21 February, 2018

RE: PROPOSED REDEVELOPMENT OF COCKLE BAY WHARF

1. As requested, we have reviewed the traffic matters raised by RMS, TfNSW and City of Sydney with respect to the above development. Our response is set out in the attached table.
2. We prepared the traffic report that accompanied the SSDA for the above development (Traffic Report for Revised Proposed Development of Cockle Bay Park, Darling Harbour – September 2017).
3. In summary the matters raised by RMS, TfNSW and City of Sydney can be addressed through conditions, amendments to the scheme or provision of additional information as part of a Stage 2 DA.
4. We trust this document provides the information you require. If you should have any queries, please do not hesitate to contact us.

**14.5m BUS VEHICLE SWEEP  
 PATHS**

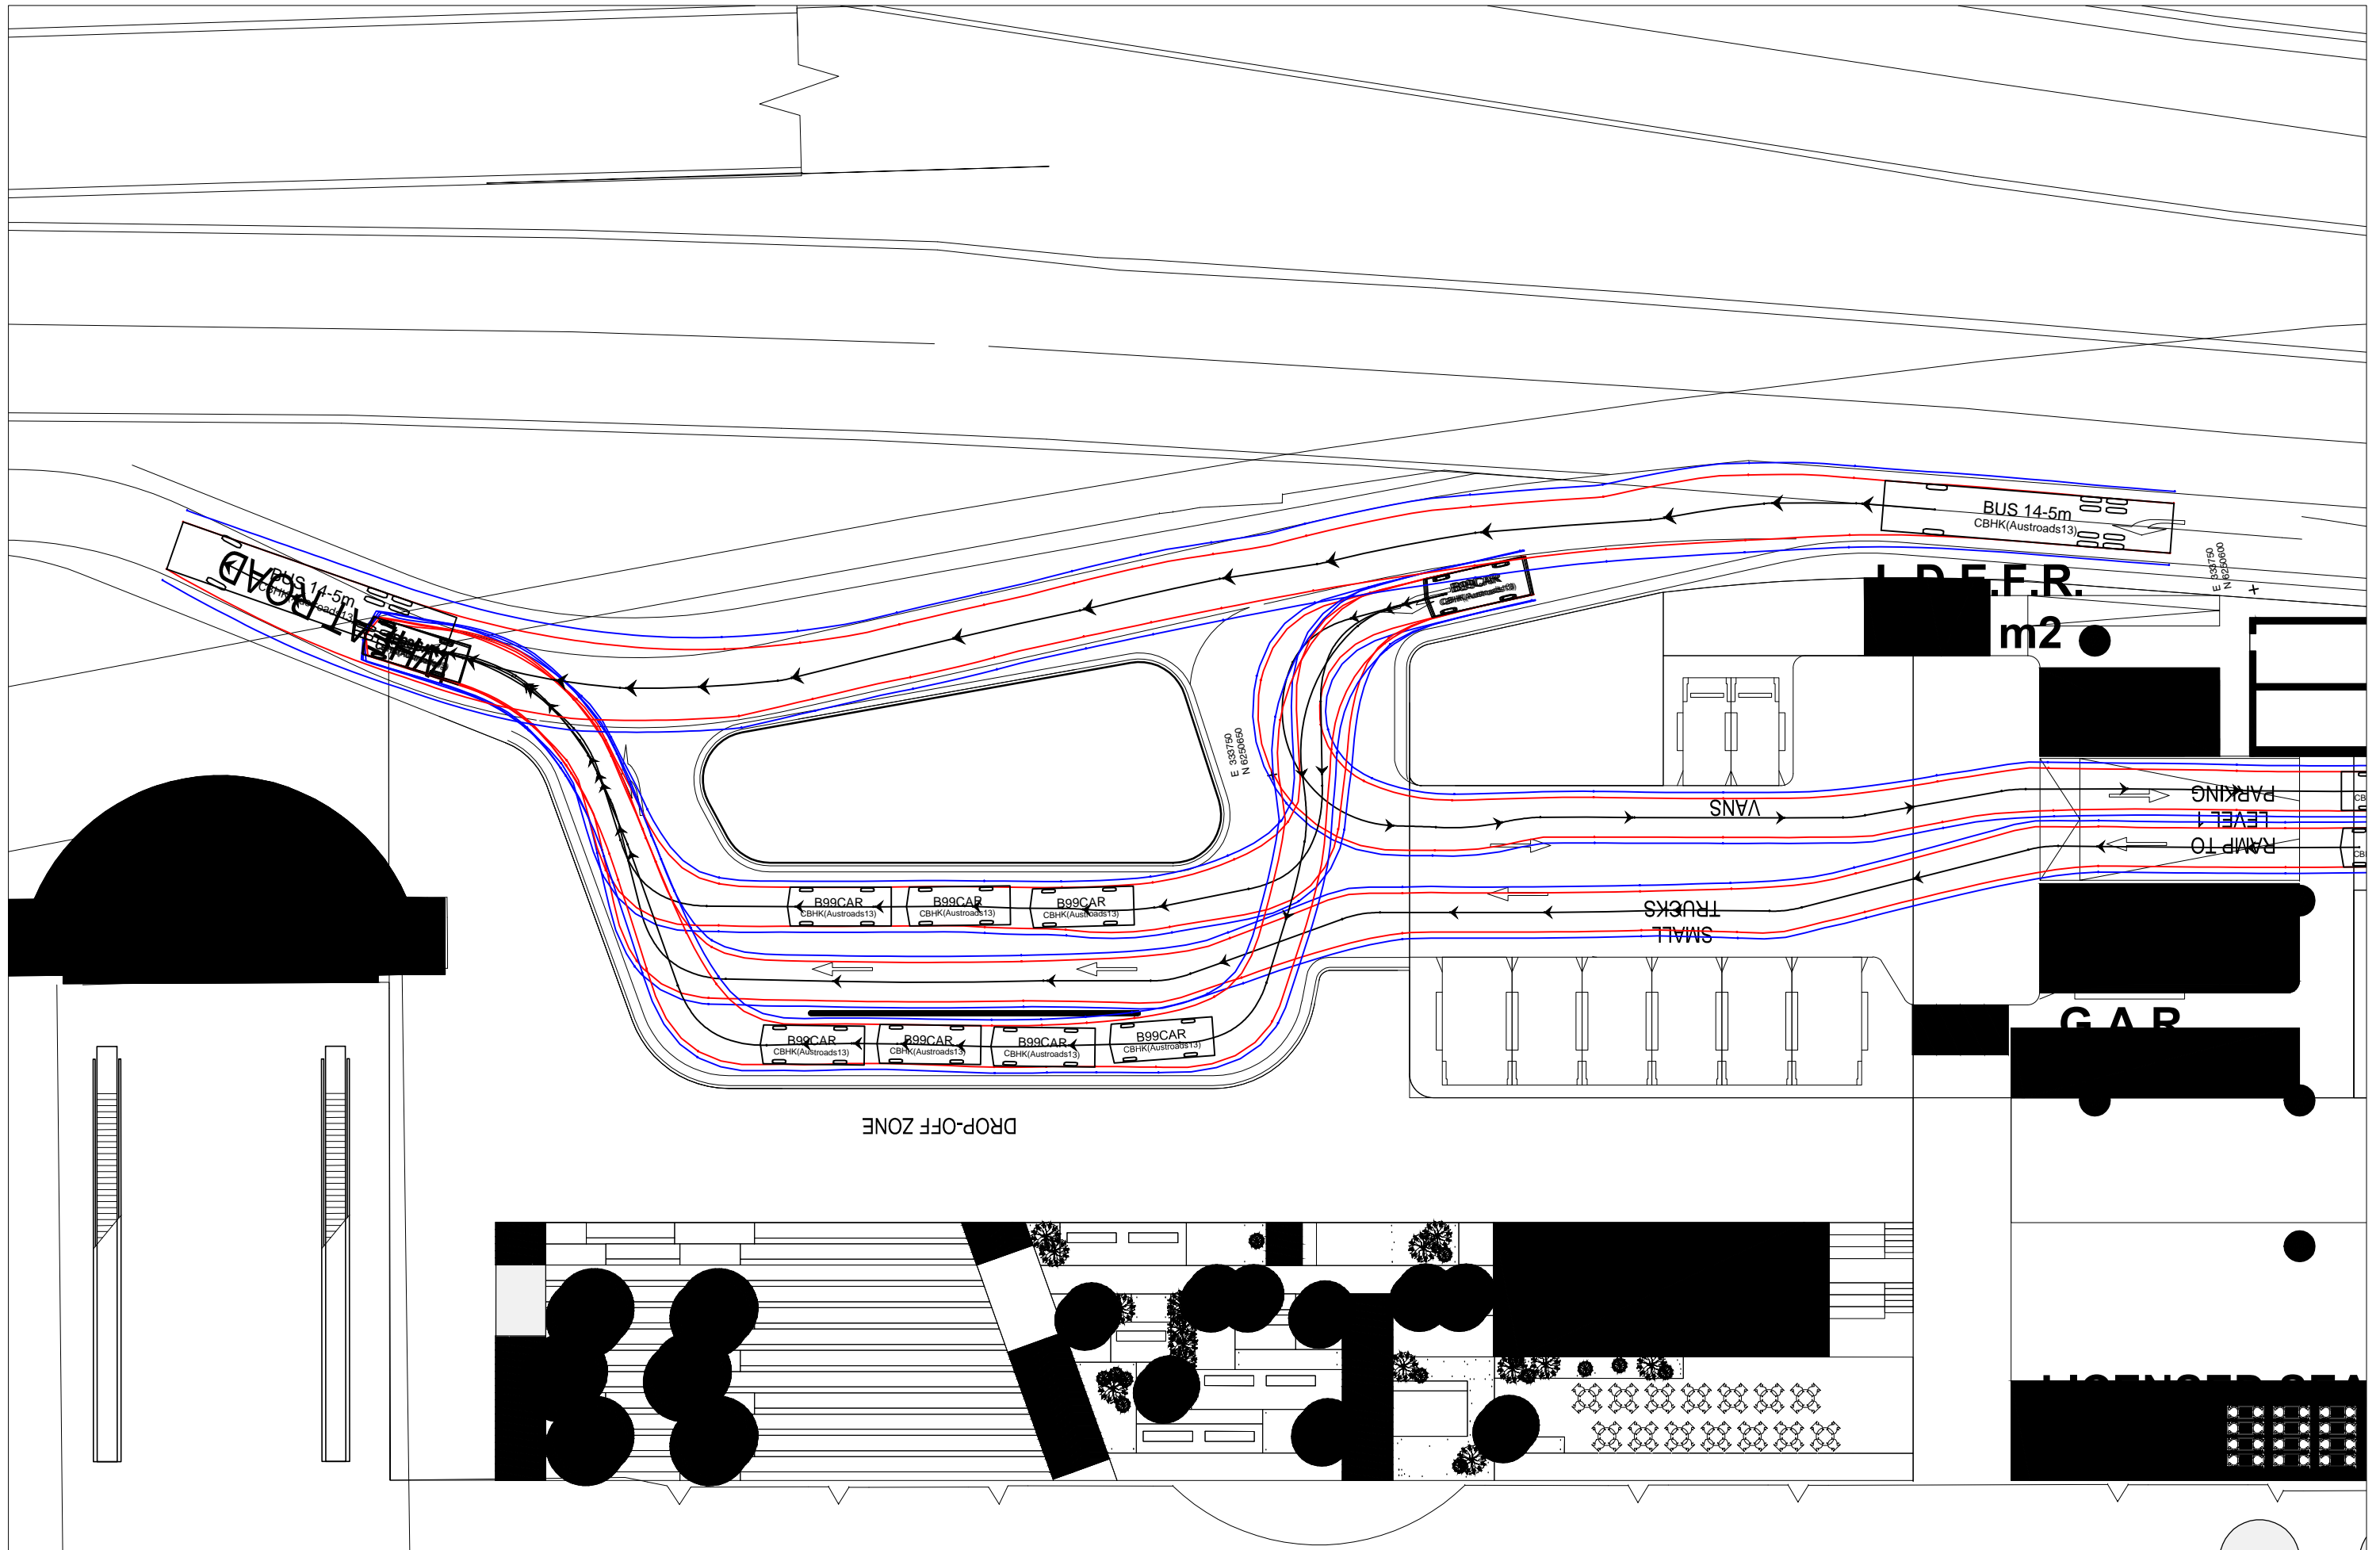
Provision of truck paths into/out of the site and on Wheat Road	Truck paths were provided in our traffic report (Attachment B). Updated truck paths will be provided in a Stage 2 DA.
Car park entry to the new car park requires 2 way access out of the Ribbon development which is not possible	Modifications to the Ribbon development were identified to provide 2-way access and address the matters raised by CoS. Notwithstanding this, as RMS has not supported the signalised right turn from Wheat Road onto Harbour Street, the connection from the Ribbon development onto Wheat Road will remain one-way.
Concern about the operation of the southern connection from Wheat Road to Harbour Street, in particular the proposed signalised right turn onto Harbour Street	As noted above the RMS does not support the proposed right turn egress but does not object to a priority controlled left turn egress.
CoS requests detailed information on the operation of proposed porte cochere located at the northern end of the site to demonstrate that it does not impact on the through traffic travelling north of the site	The concept plans show parking for 7 vehicles in the northern porte cochere with additional queuing available. This is an improvement over the existing situation. A more detailed assessment will be undertaken as part of a Stage 2 DA.
